Subject: RE: REF 2025/62/91542/E : 39134 - Highmoor Lane, Cleckheaton - Section 38 and 278 Application

They have also not considered the points raised by Highway Safety and HDM in the previous consultation response dated 1st October as follows.

Phoenix 2 Duo (P2-15W with Elite 6x4 chassis)
 Overall Length 11.200m
 Overall Width 2.530m
 Overall Body Height 3.751m
 Min Body Ground Clearance 0.304m
 Track Width 2.500m
 Lock to lock time 4.00s
 Kerb to Kerb Turning Radius 9.500m

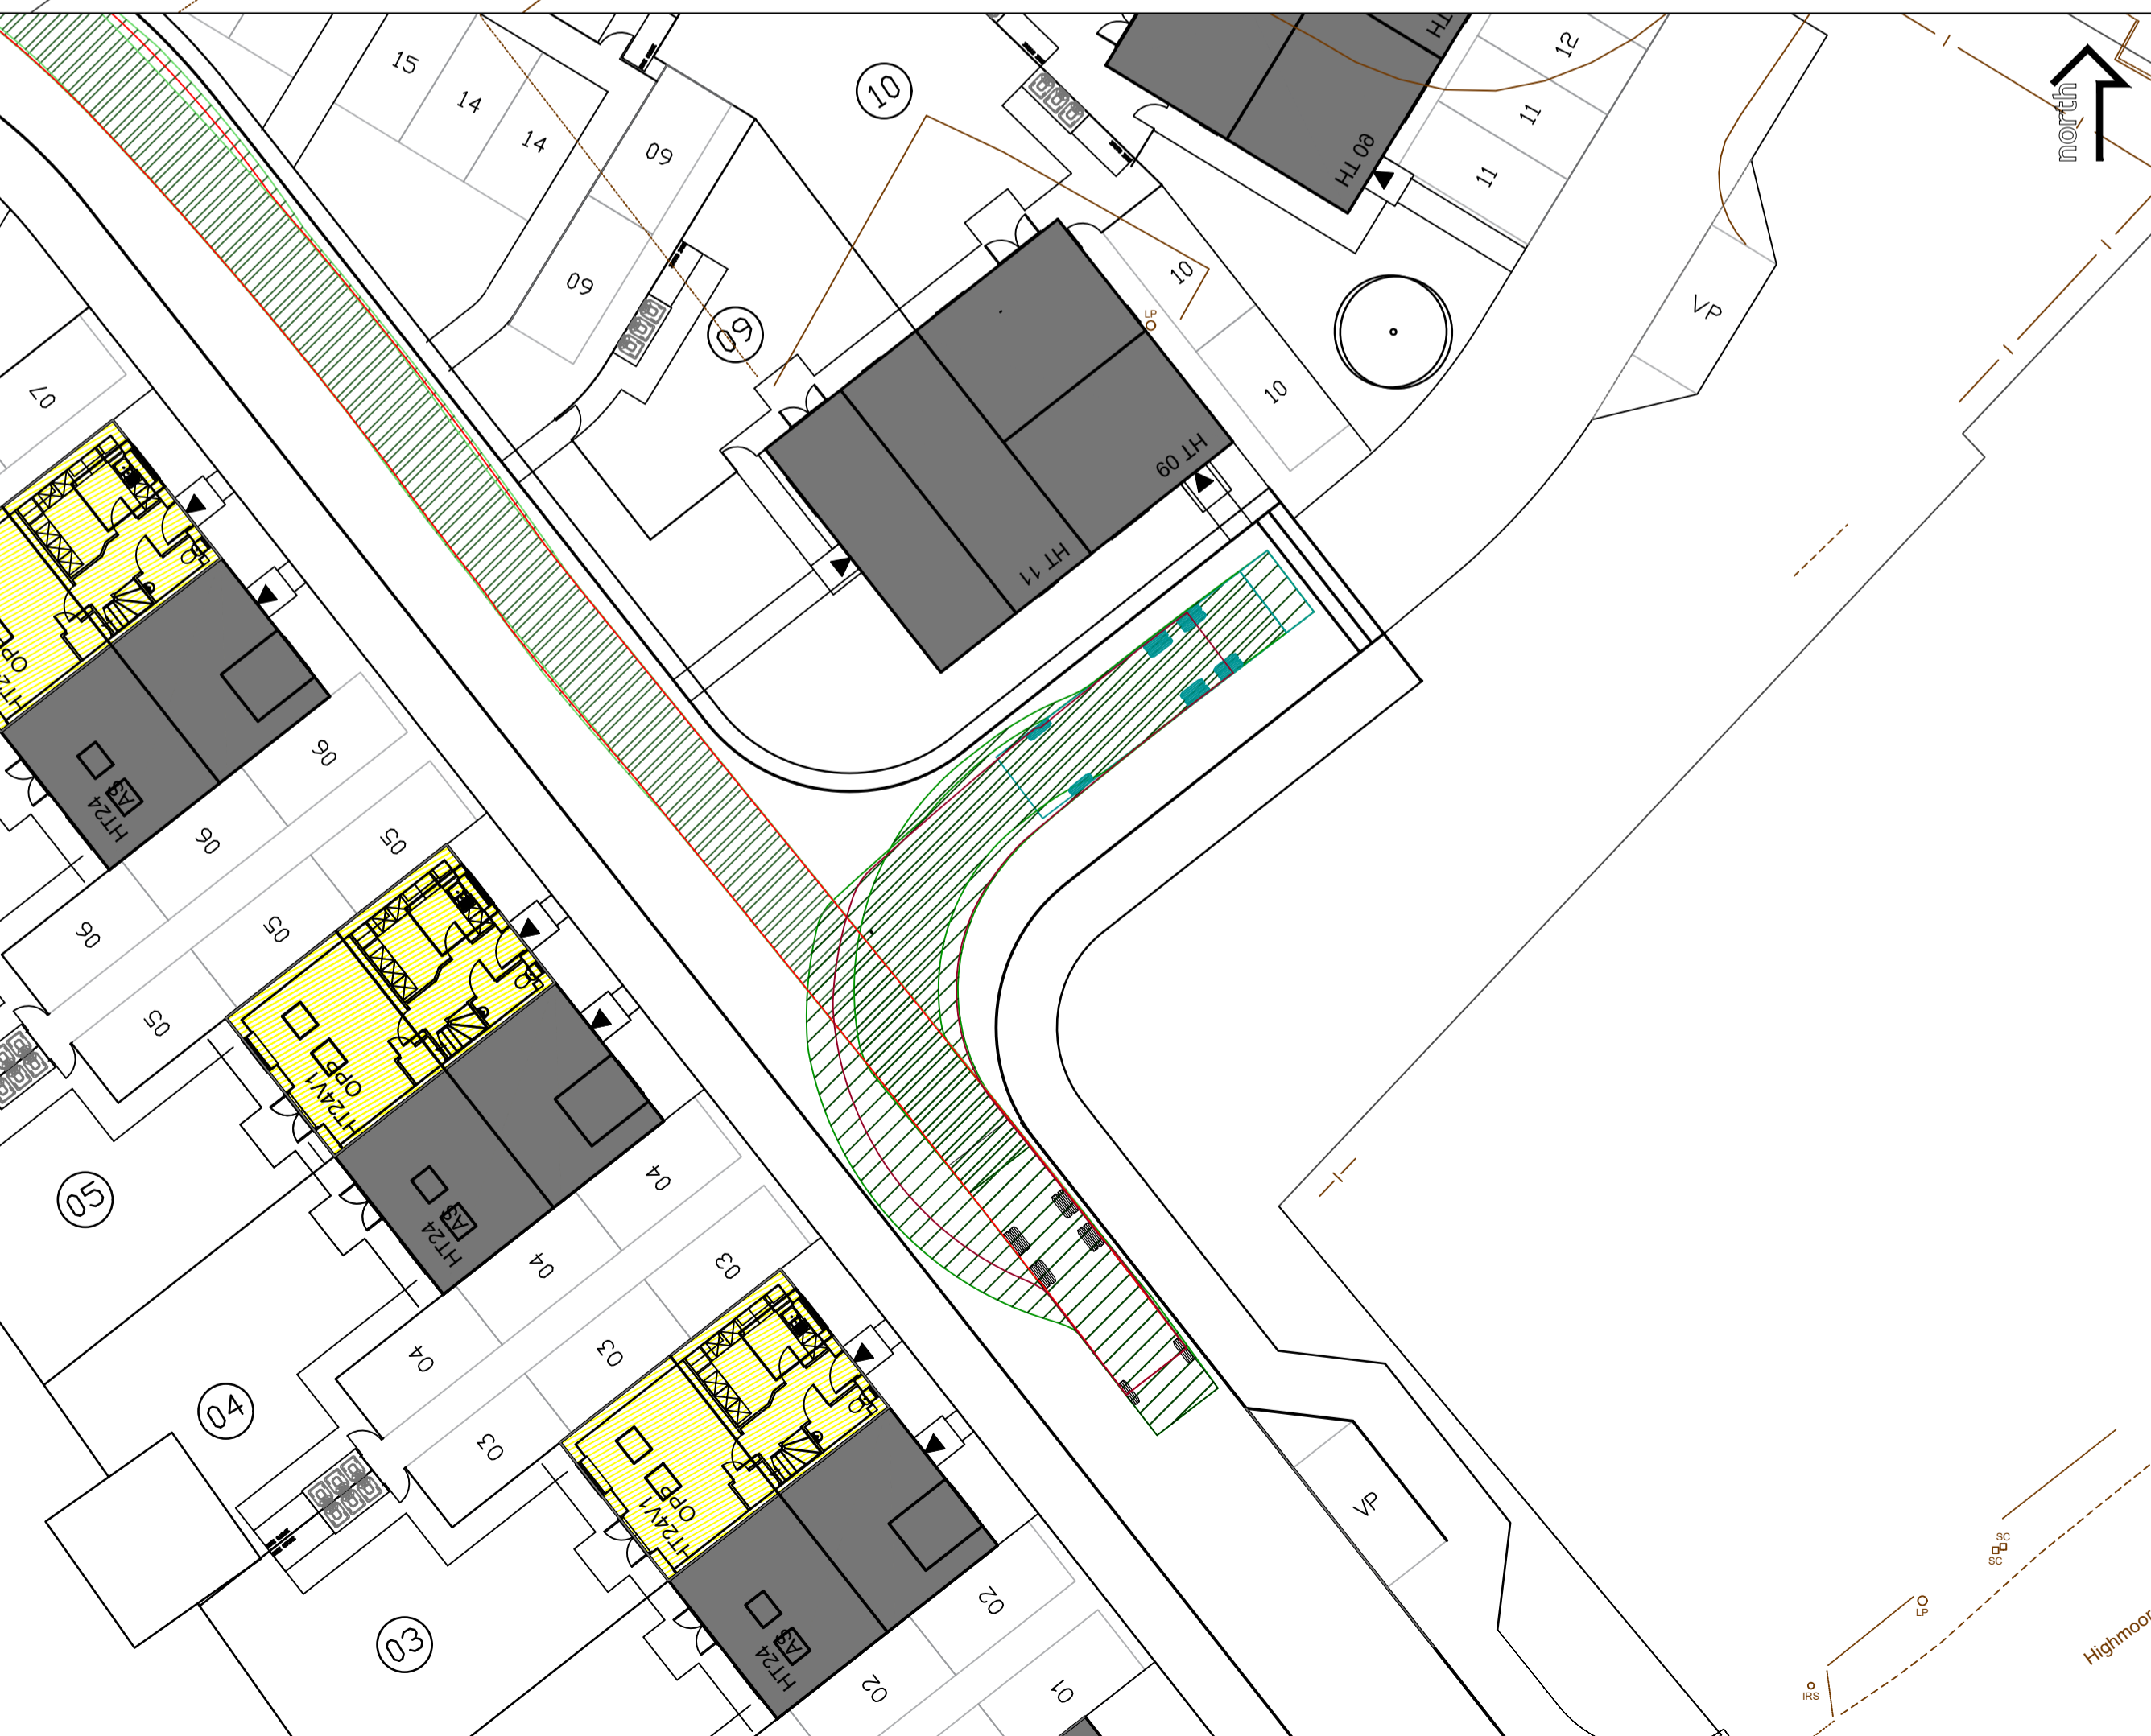
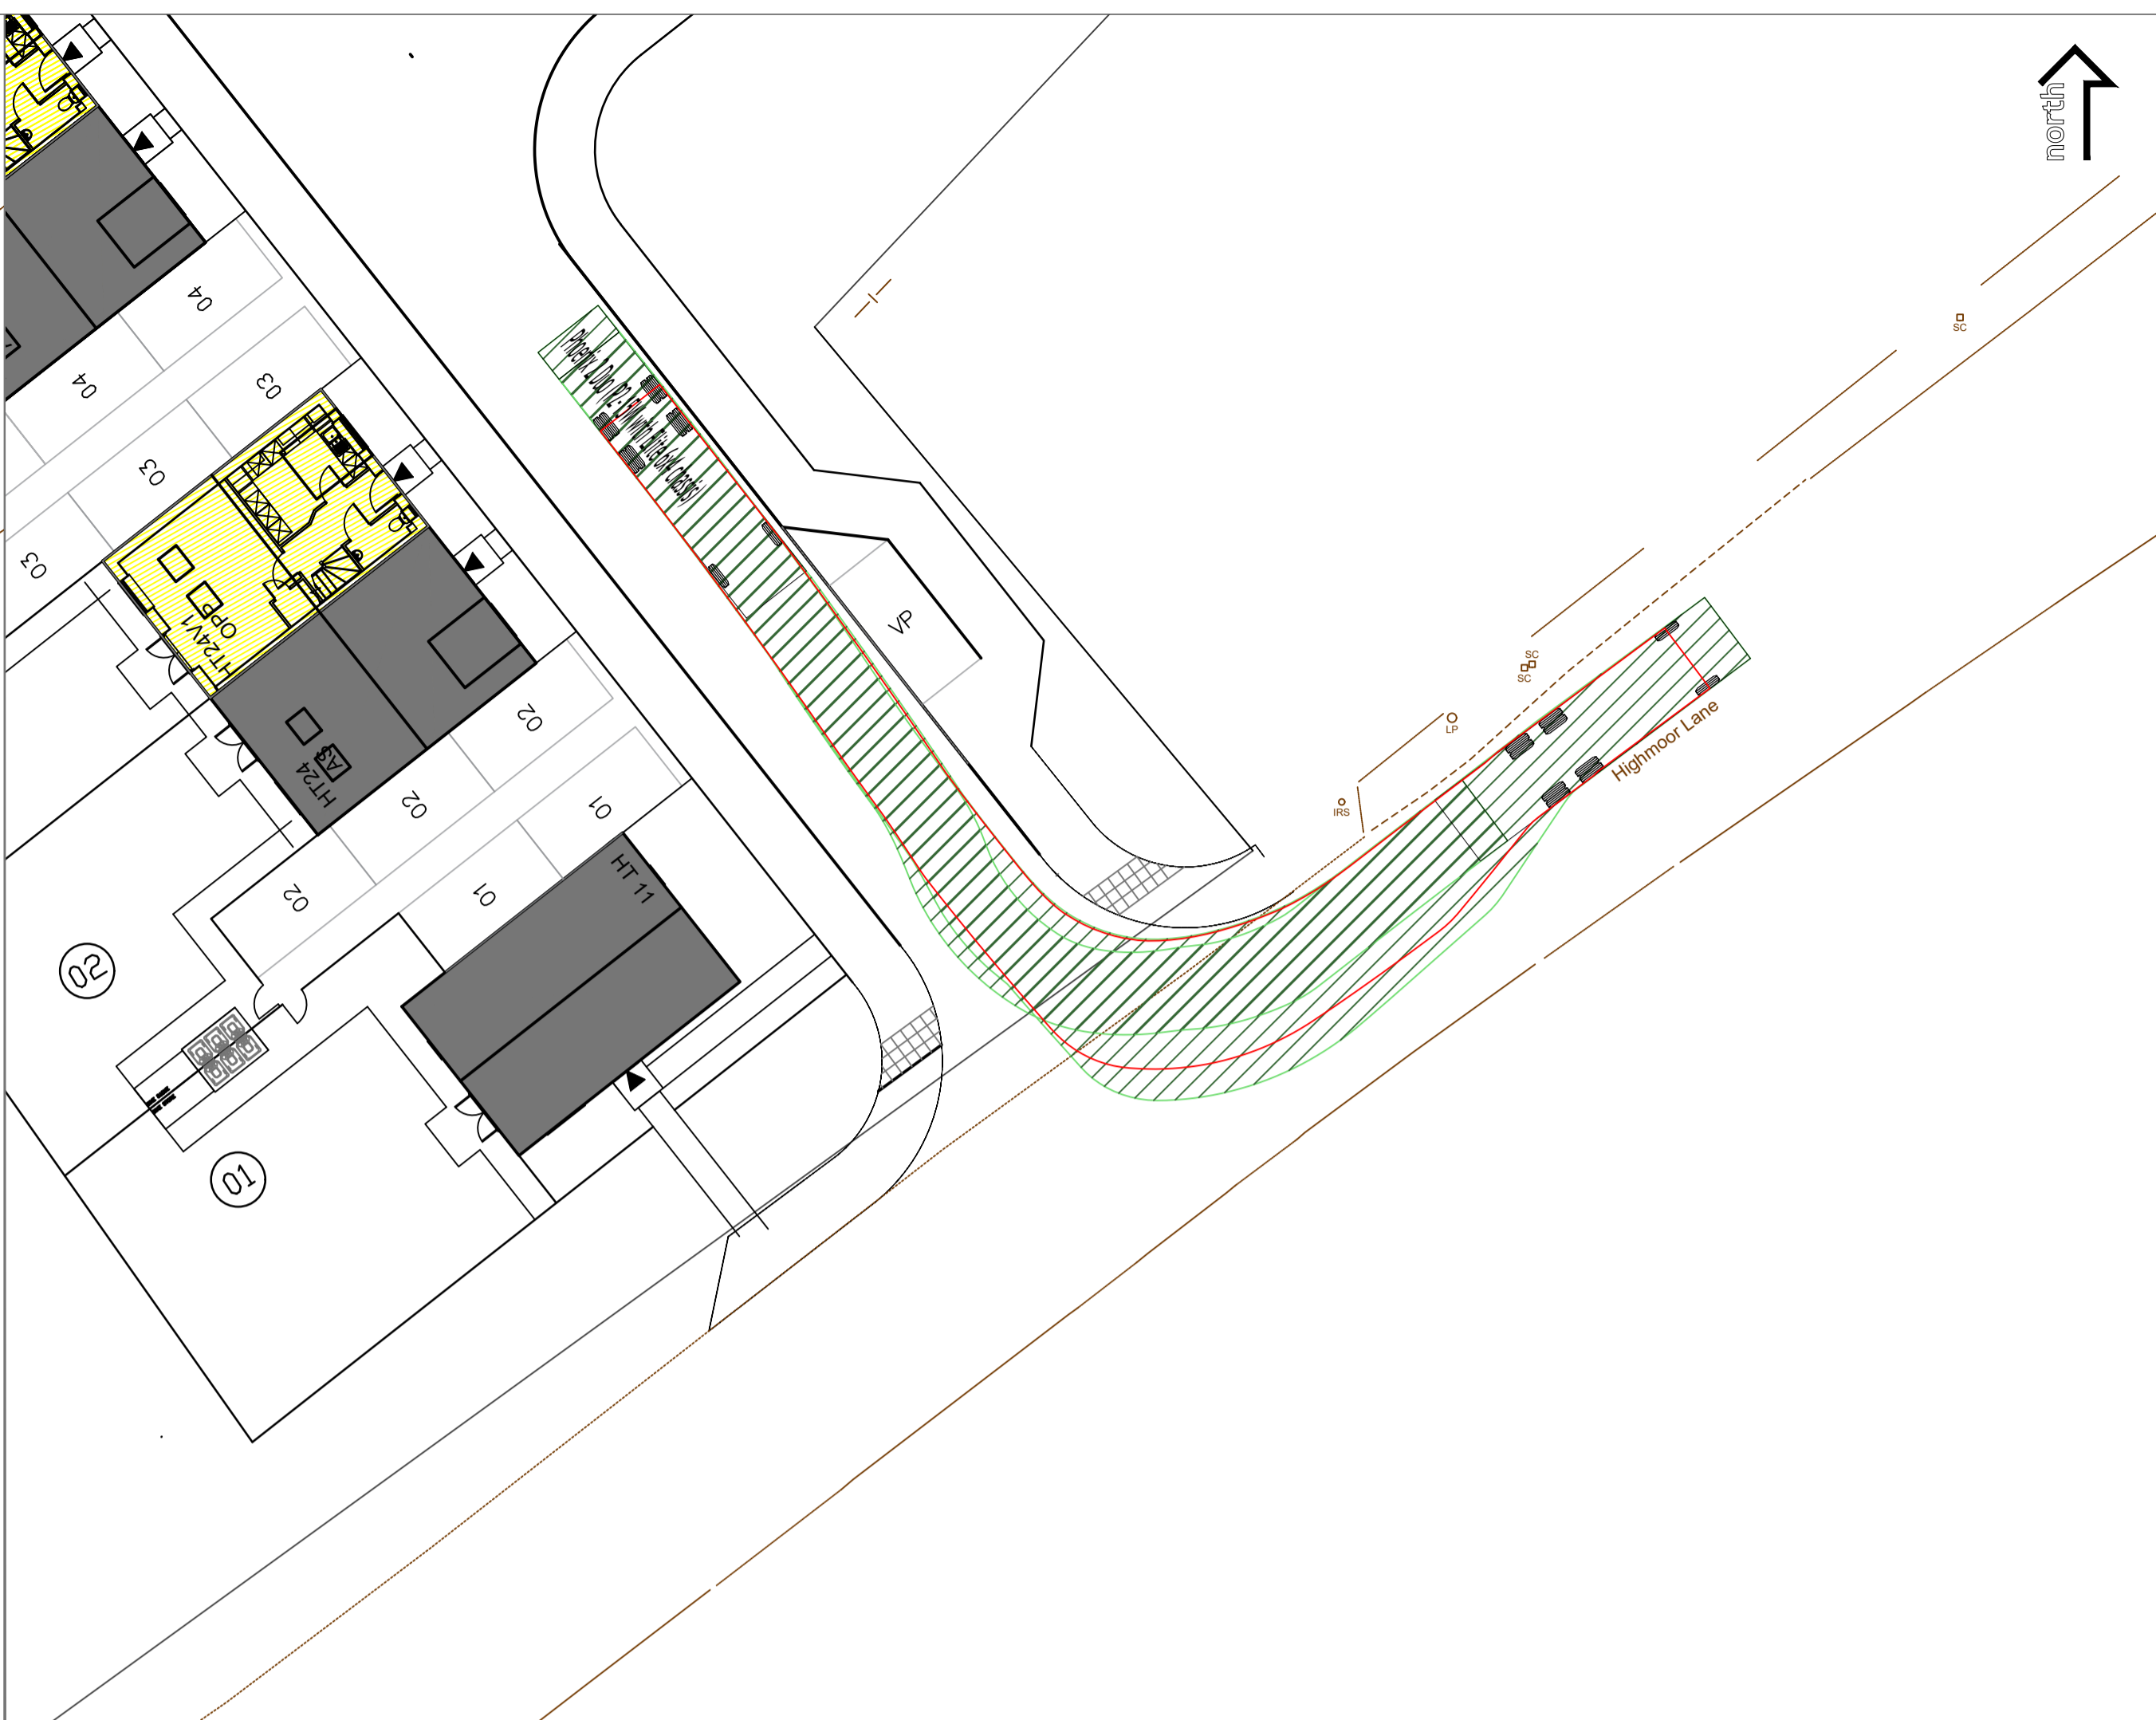
5, Swept paths should be provided which demonstrate that an 11.85m refuse vehicle can enter and exit the site from Highmoor Lane and turn within the site. All schemes must incorporate reasonable tolerances and safety margins. A good starting point is to allow 0.5m clearance to kerbing or vertical obstructions on
